Reference: M42 Junction 6 Improvements - The Examining Authority's third written questions and requests for information (ExQ3)

ExQ3.5.5: Mitigation and monitoring: Ancient Woodland - The ExA would welcome comments from Natural England, The Woodland Trust and SMBC on the Applicant's Soil Survey Report [REP4-007] submitted at Deadline 4.

The Woodland Trust's comments on the Soil Survey Report submitted by the applicant are as follows:

Map title:
 Map 3
 Soil resources

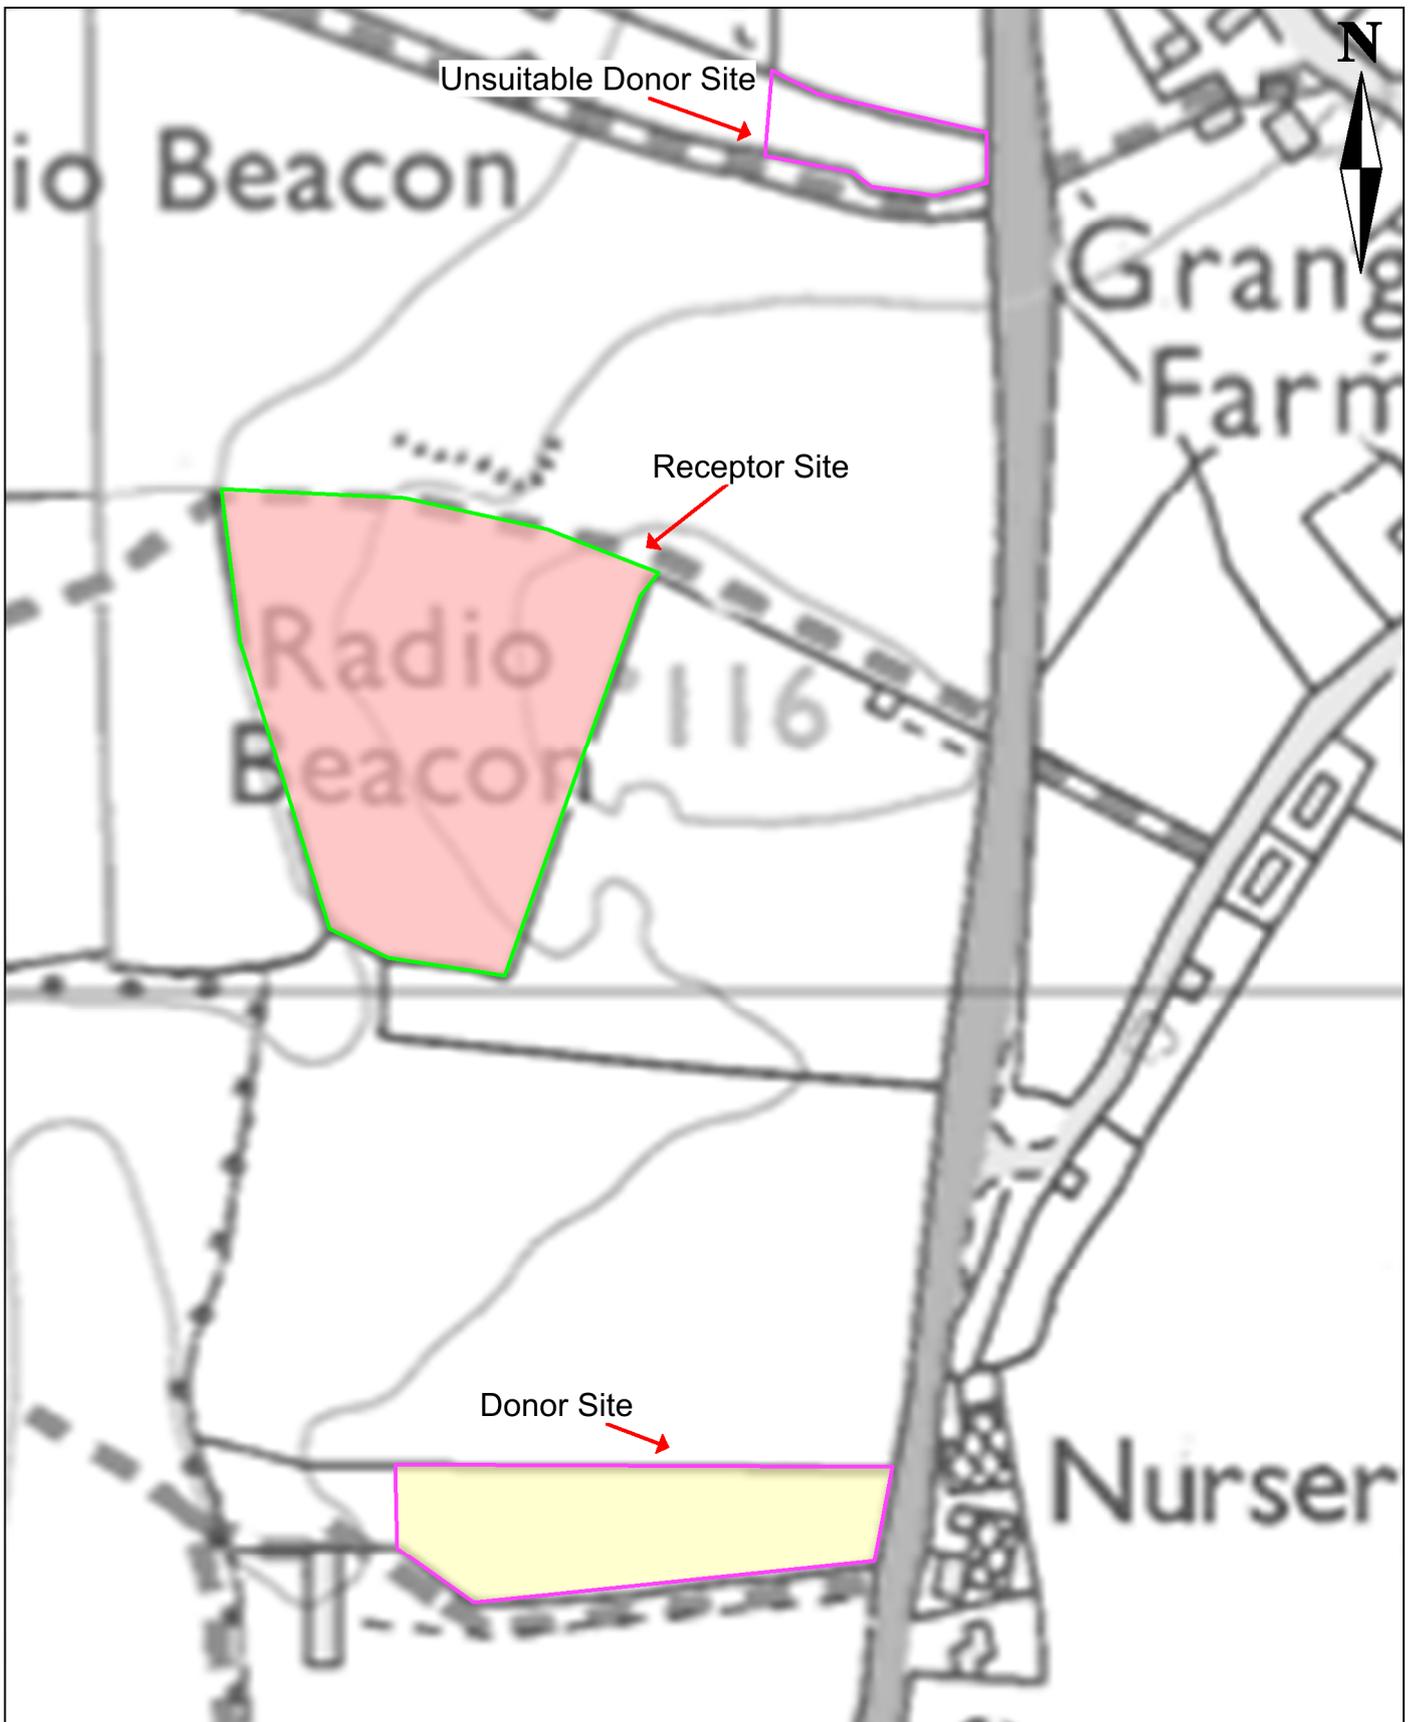
Section 4 (Soil suitability and resources): The Trust acknowledges the applicant's attempt to replicate the soil qualities of the donor and receptor sites. However, we hold concerns with regards to the nutrient content of the receptor site, as this is likely to encourage the growth of more ruderal species that are likely to out-compete the more sensitive, ancient woodland flora.
